Ribble Valley Borough Council  
Housing & Development Control

Application no: **3/2022/0632**

Address: **Pendle Mill Pendle Road Clitheroe BB7 1JQ**

Proposal: **Demolition of existing buildings and erection of a care home (Use Class C2) of up to 70 beds. All matters reserved apart from access.**

Drawing Title
Existing and Proposed Site Section C-C

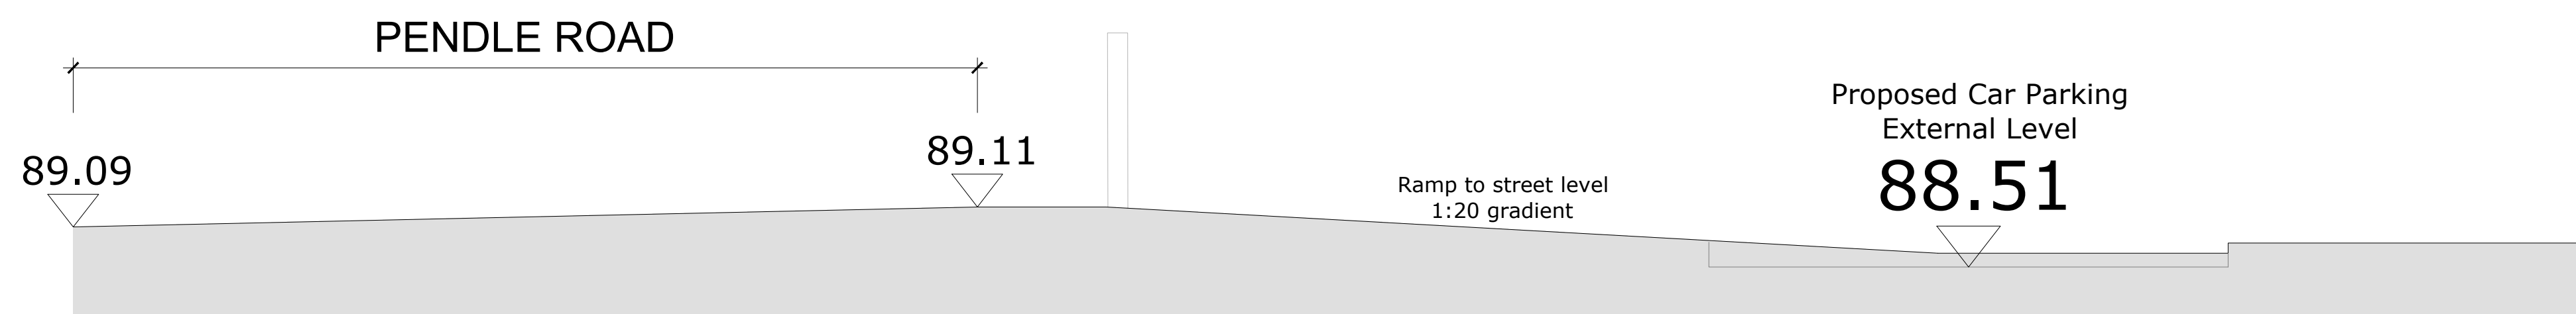
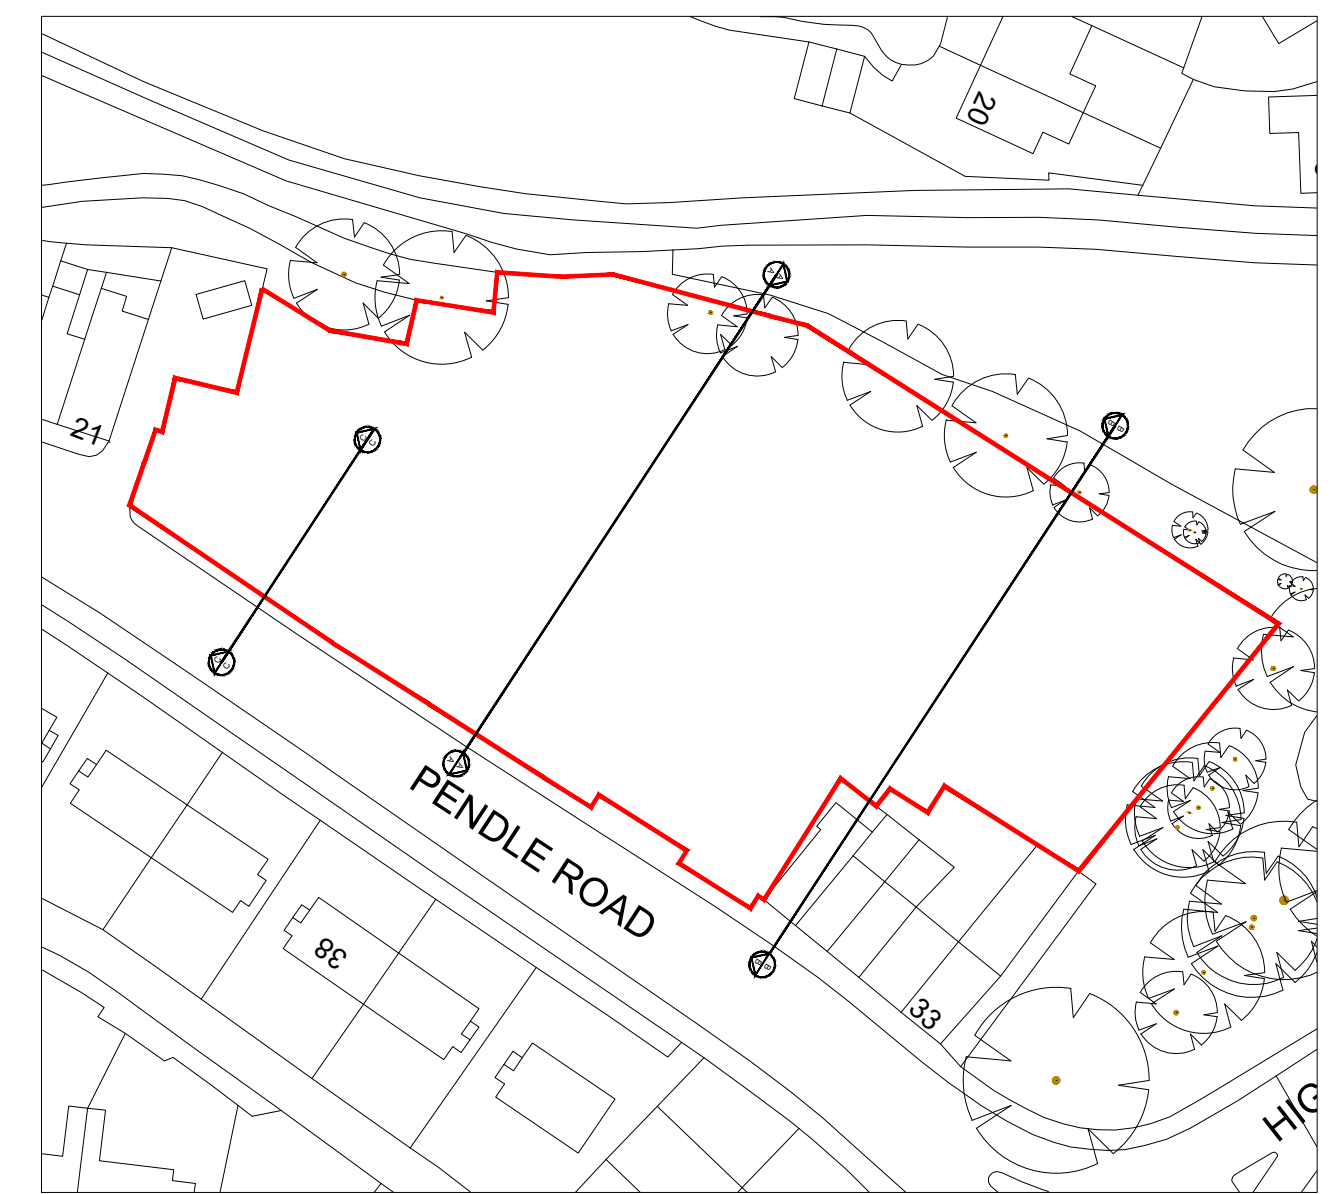
Before reviewing the technical details of the proposed access, the LHA are aware by visiting the site and by reviewing Google Streetview that there is a level difference at the proposed site access between the highway and the internal road network. The LHA have reviewed the Muller drawing number (9-) 22 titled "Existing and Proposed Site Section C-C" and are aware that the level difference between the adopted highway and the proposed access will be no greater than 1 in 20, which complies with the LHAs guidance.

However, to erect the access, the retaining wall structure located at the back of the existing footway fronting Pendle Road will need to be altered. The LHA inform the Agent and Applicant that any change to this feature will need a technical drawing to be submitted to ensure that any change will not destabilise the adopted highway. This can be conditioned at a later stage.

Drawing Title
 Proposed Site Plan with Culvert and Trees

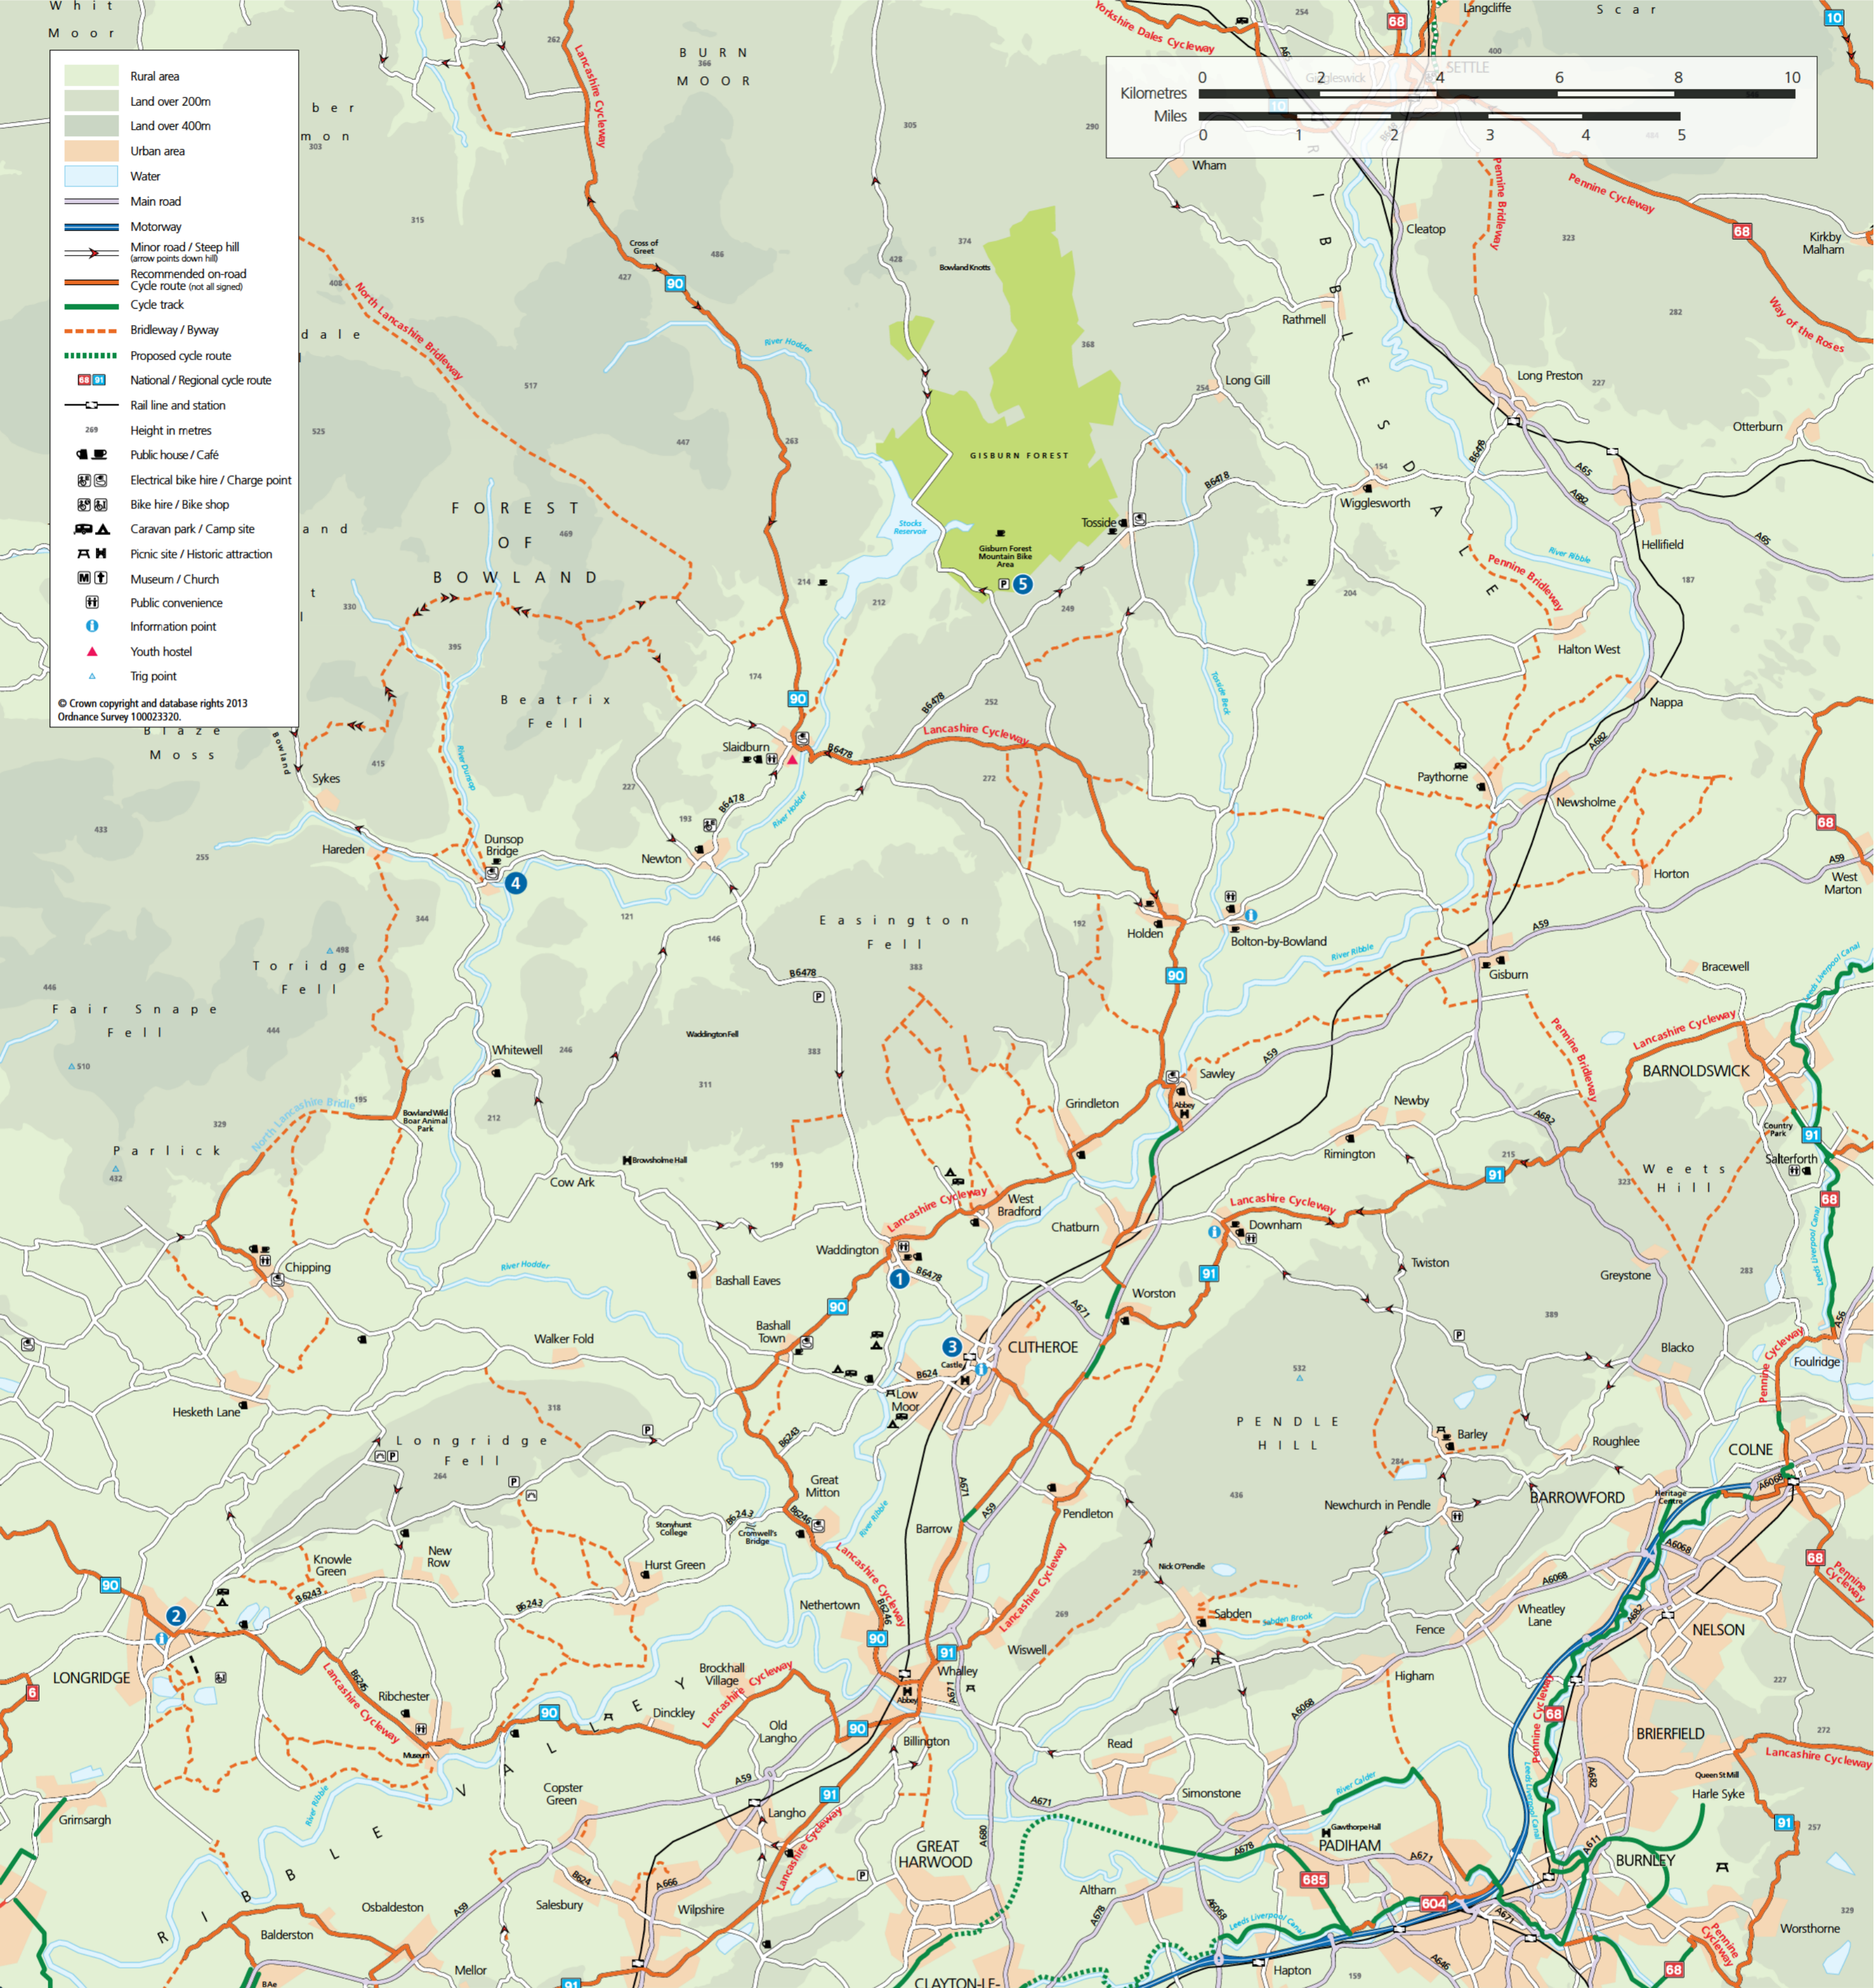
In any case, the LHA have reviewed Sanderson drawing number 300828-001 Rev A titled "Proposed Access Arrangement and Visibility Splays," and are aware that the site will provide 28 car parking spaces for the site, including two disabled bays and 3 Electric Vehicle charging points.

Given that the proposed parking arrangements complies with the LHAs parking guidance as defined in the Joint Lancashire Structure Plan, the LHA accept the number of parking spaces proposed at the site.

However, the LHA will require the internal area of the site, as mentioned in the Site Access section of the report, to incorporate a turning area and a designated area for servicing and for emergency vehicles to use.

The use of these areas should be complimented by a swept path analysis drawing of a refuse vehicle entering and exiting the site in a forward gear.
